Appeal Decision

Appeal Ref: APP/R4408/D/25/3370818

25 Cloisters Way, Monk Bretton, Barnsley S71 2JN

- The appeal is made under section 78 of the Town and Country Planning Act 1990 (as amended) against a refusal to grant planning permission.
 - The appeal is made by Mr Peter Tomes against the decision of Barnsley Metropolitan Borough Council.
 - The application Ref is 2025/0237.
 - The development proposed is rear metal first floor balcony with side screening and glass balustrade.
-

Drawing No.	Rev No.
MPT001 -003	A

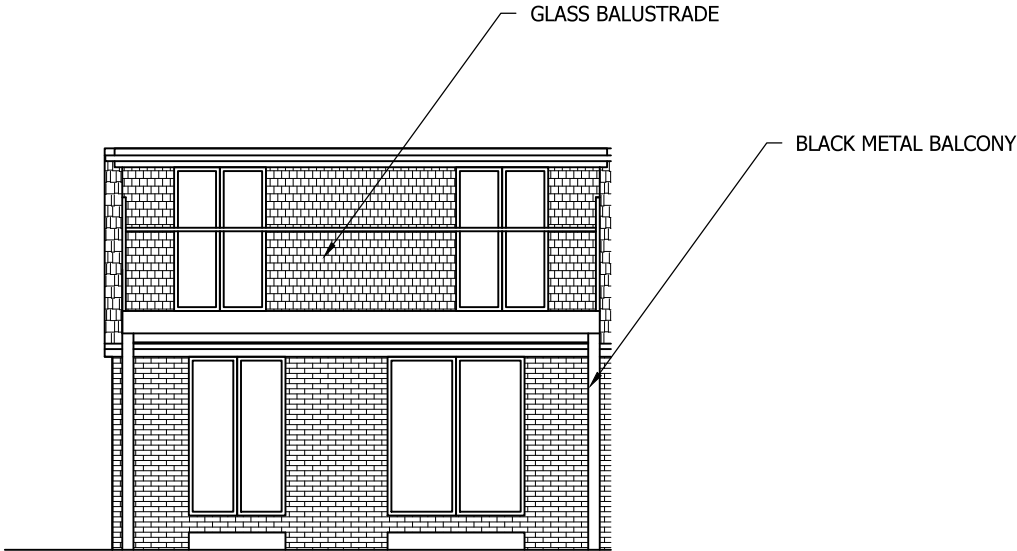
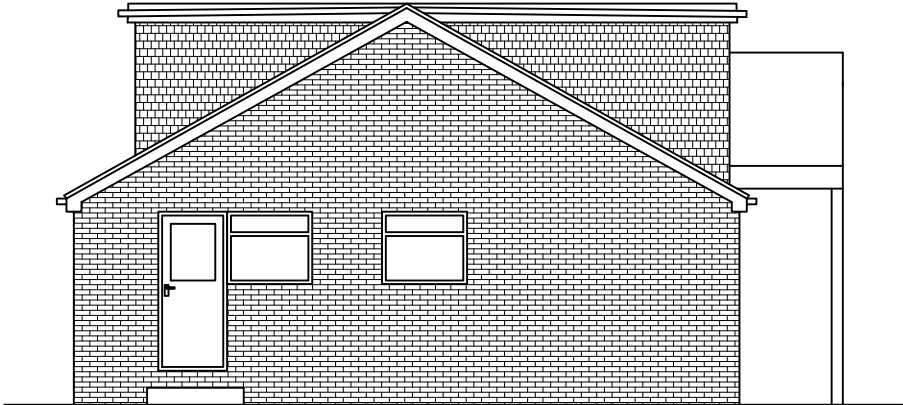
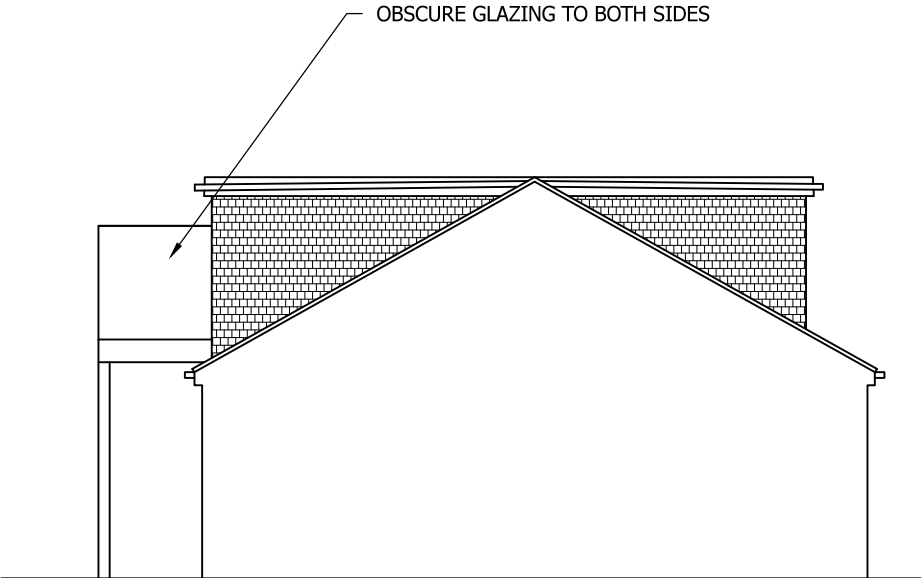
6. The appeal scheme would therefore introduce an incongruous feature, made more conspicuous by the use of metal and glass for the balcony, materials that are not characteristic to the property. Spanning the full width of the dwelling, the balcony would also dominate the rear elevation of its host which, when combined with the existing extensions to the appeal property, would appear disproportionate to the modest scale of the original dwelling.

8. The proposed balcony would incorporate obscure glazing to each side. Nonetheless it would afford occupiers of the host dwelling views into the rear garden of the attached dwelling at No 23. Owing to its height and close proximity to the shared boundary, the development would result in a greater level of overlooking than the existing dormer windows. This impact would be particularly evident to occupiers of No 23, given the modest size of their rear garden and the difference in site levels between the properties. As a result, the proposal would lead to an unacceptable loss of privacy for occupiers of No 23, to the detriment of their living conditions.

9. While I acknowledge that the proposed balcony would be of limited depth, the obscure-glazed end panel would add a perceptible sense of bulk when viewed from the rear garden of No 23. Along with the proximity of the proposal to No 23, this would have an overbearing effect on their outlook. In addition, the use of the balcony would give rise to increased levels of activity and associated noise, which, given the balcony's elevated position, would be more readily experienced by occupiers of No 23 than noise generated from the garden. Consequently, the proposal would further erode the living conditions of neighbouring occupiers.

10. Having regard to the proximity of the proposed balcony to No 23, the elevated position of the appeal site, and the path of the sun, the development would also be likely to reduce the amount of light reaching the nearest rear-facing window and part of the rear garden of No 23. Accordingly, the appeal scheme would give rise to overshadowing, further diminishing the living conditions for occupiers of that property.
